Our Ref: EP/146/18/HH
Your Ref:

Town & Country Planning Act 1990 (as amended)
Town & country Planning (Development Management Procedure) (England) Order 2015
Application for Planning Permission for Works or Extension to a Dwelling

Development Two storey rear extension
Location 37 The Ridings East Preston

Block Plan

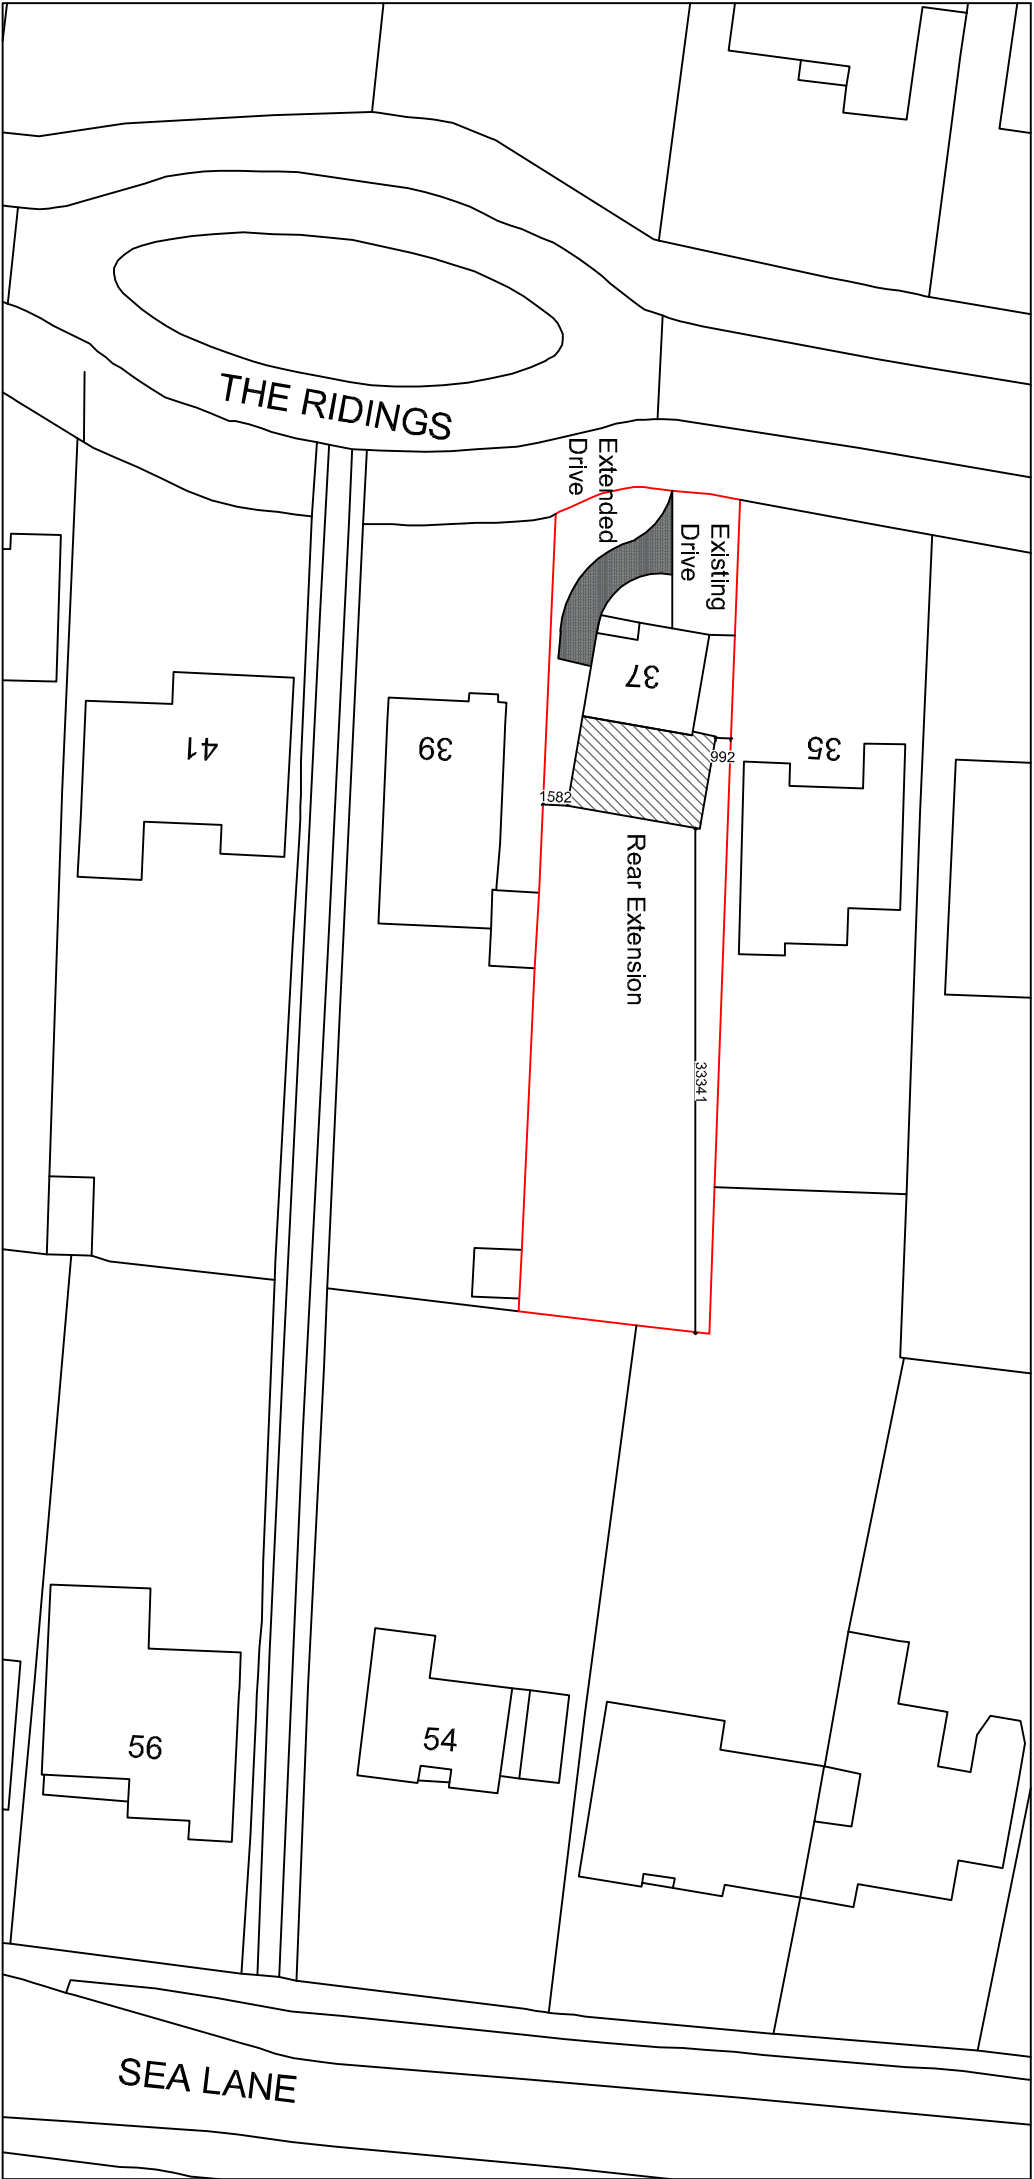
Please also annotate the dimension from the rear of the proposed extension to the rear boundary.

The block plan also shows an annotation "Extended Drive". If you are applying for this you will need to submit existing plans to clearly demonstrate the changes. This will need to be included in the description. Please confirm/amend accordingly.
